102 E. Pikes Peak, Suite 500  
Colorado Springs, CO 80903  
(719) 955-5485

January 15, 2020

**RE: Homestead at Sterling Ranch Filing No.2  
Response to Comment Letter.**

MAIL KIOSK GRADING DETAIL

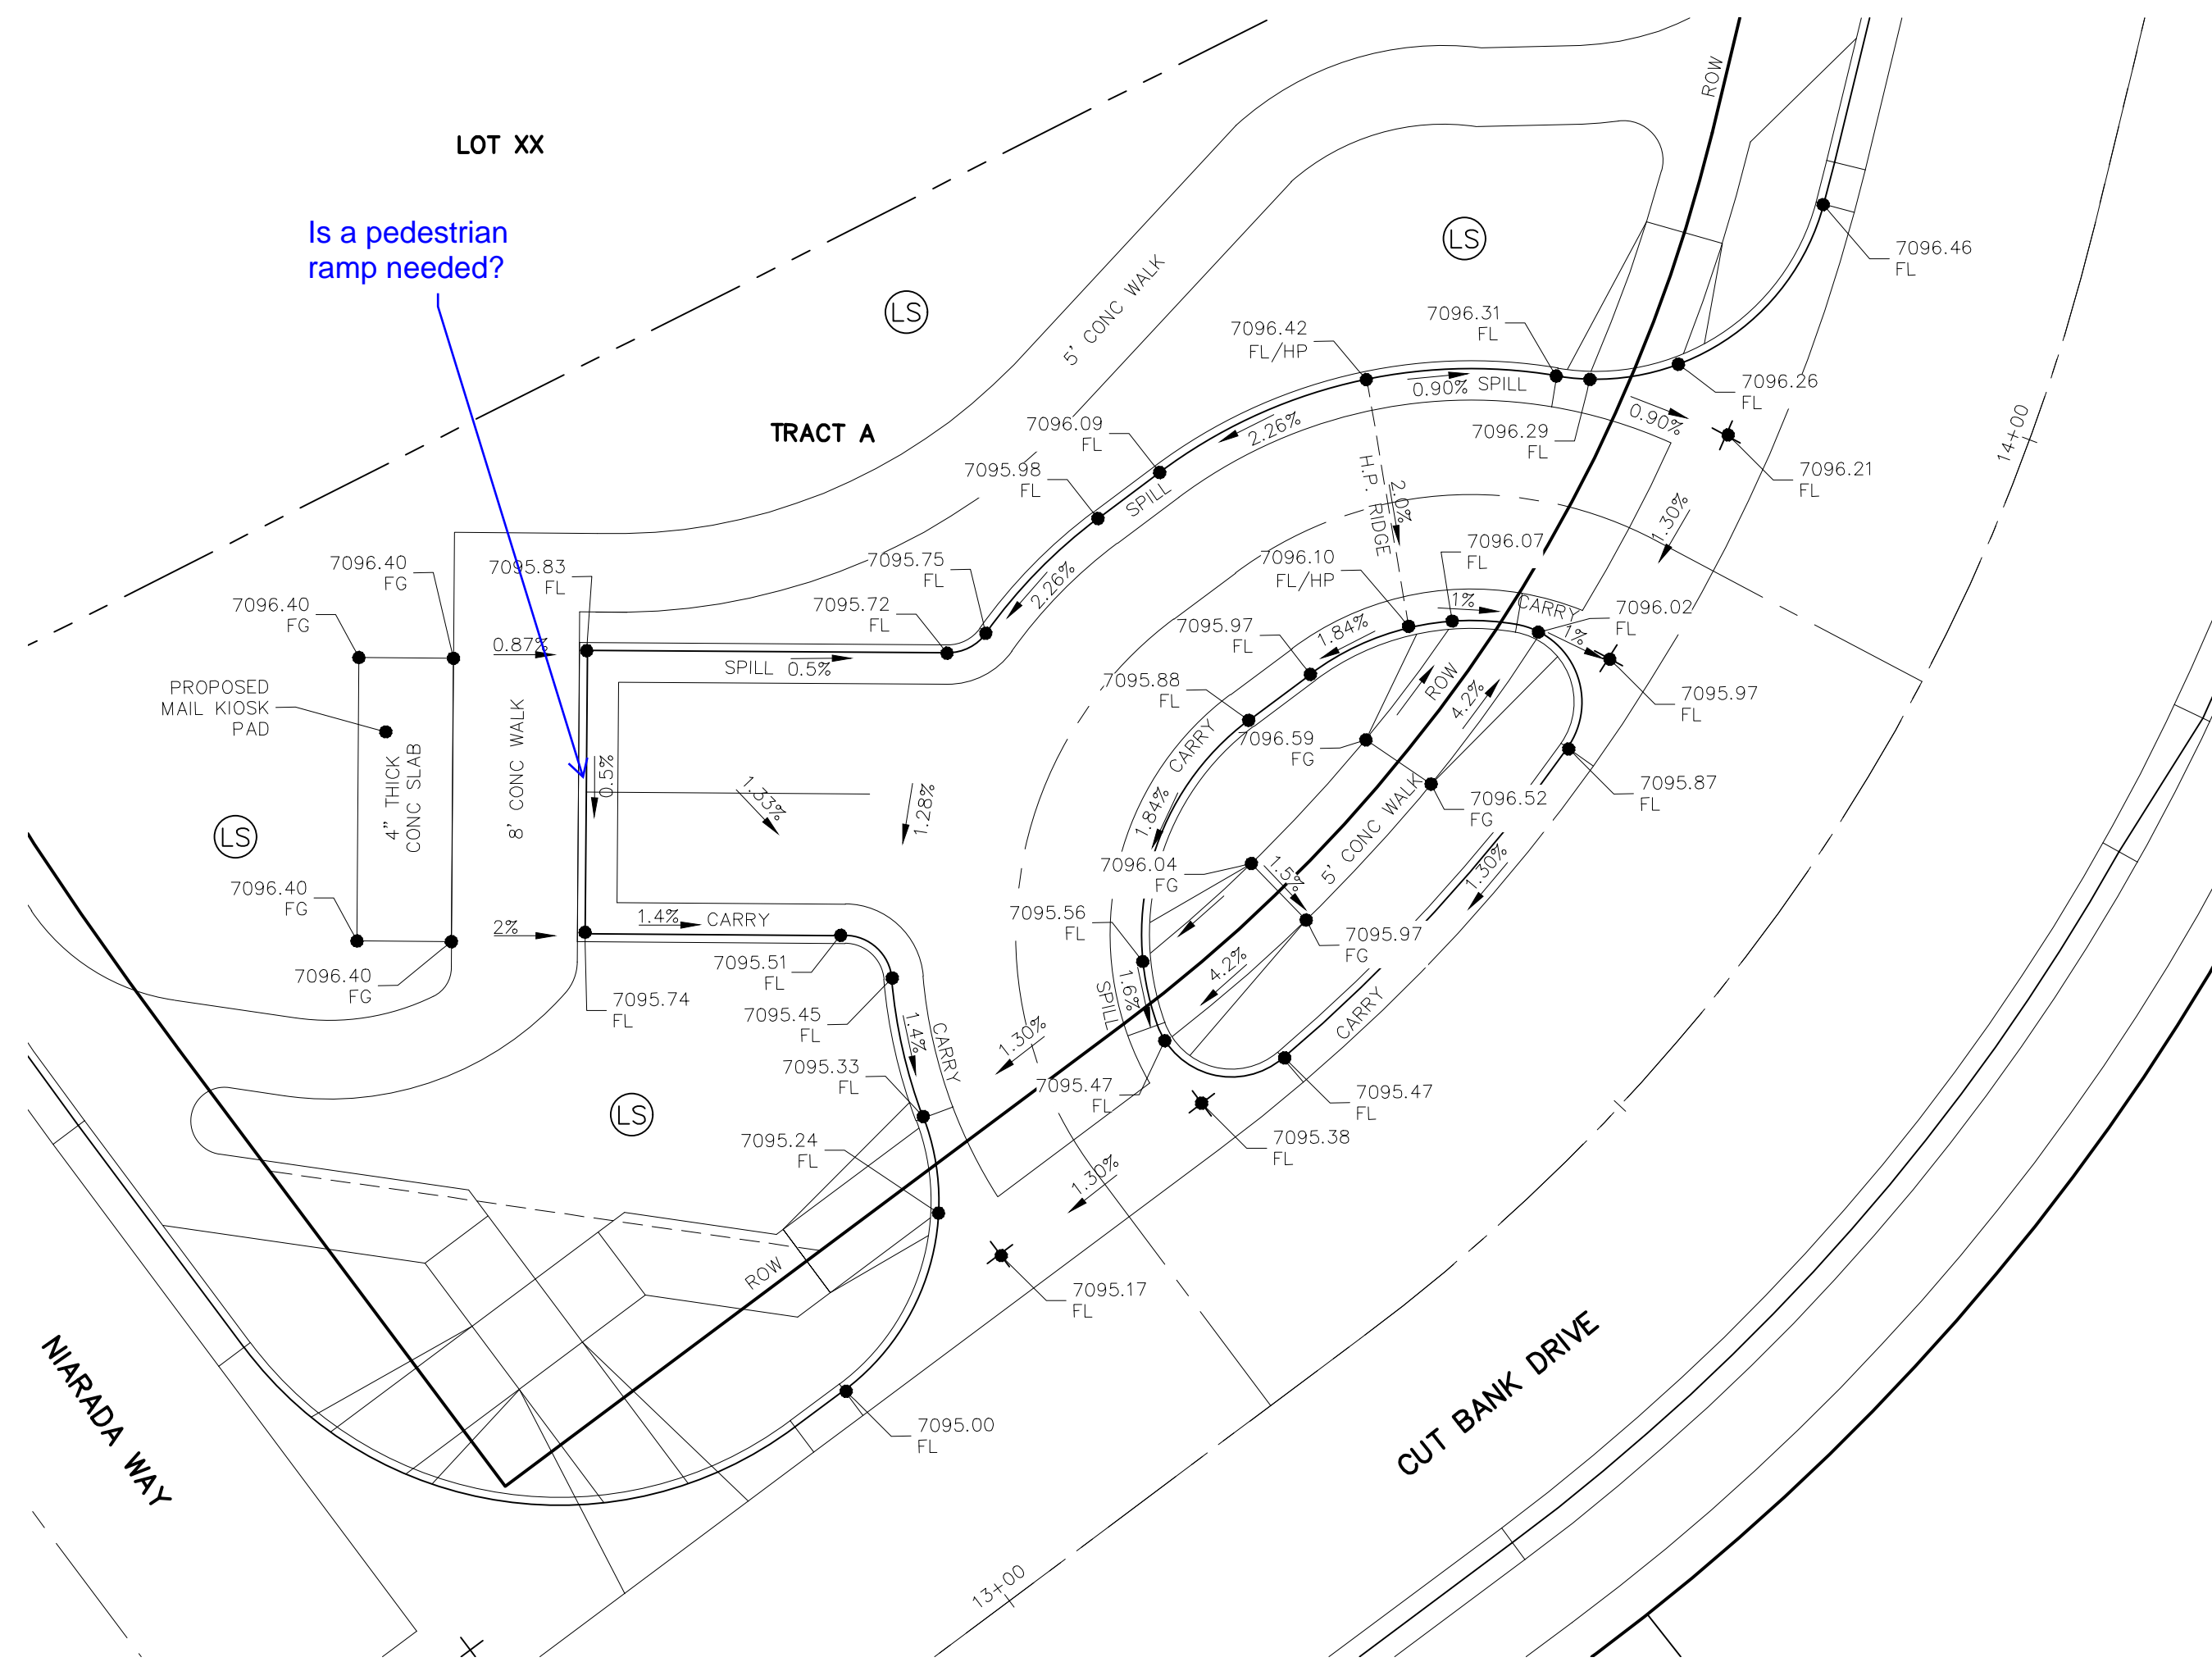
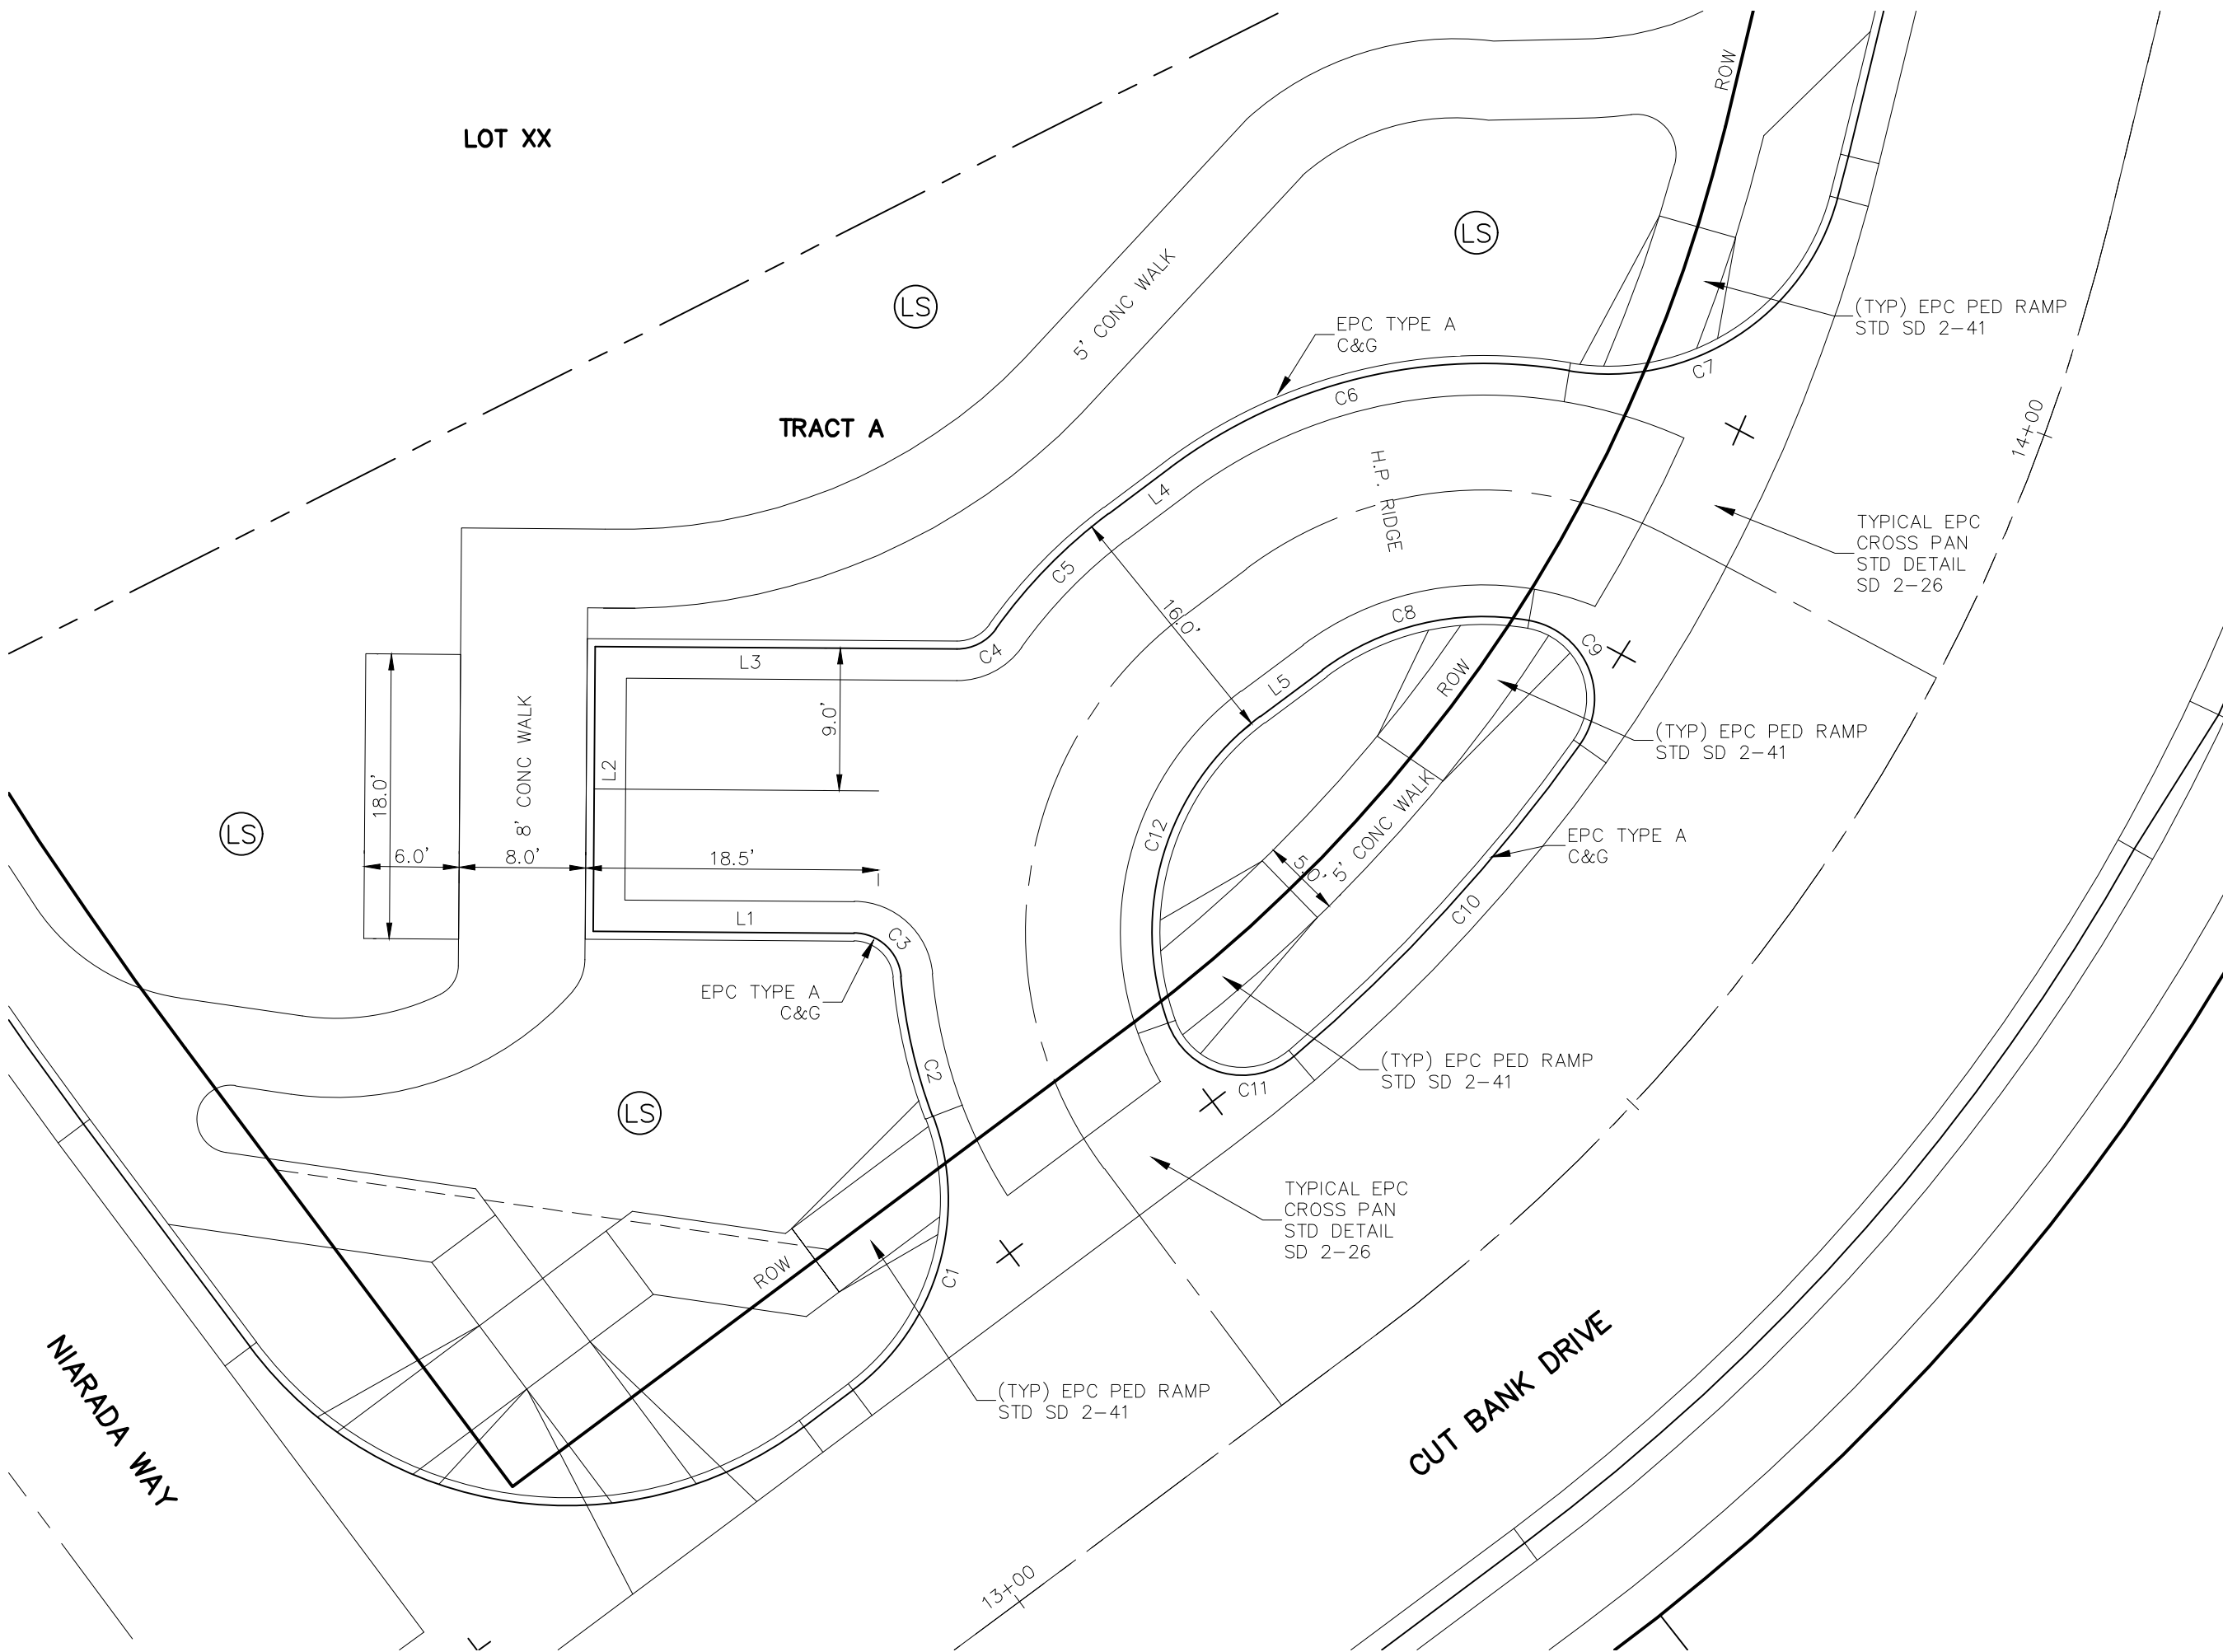
**The street profiles have been revised to show 2.0% slope transverse to the pedestrian routes. See street profiles.**
6. If there will be USPS mail kiosk/cluster(s) in this subdivision provide location(s) and details.

**The location of the mail box kiosk areas are shown on the final plat and on the street improvement plans.**
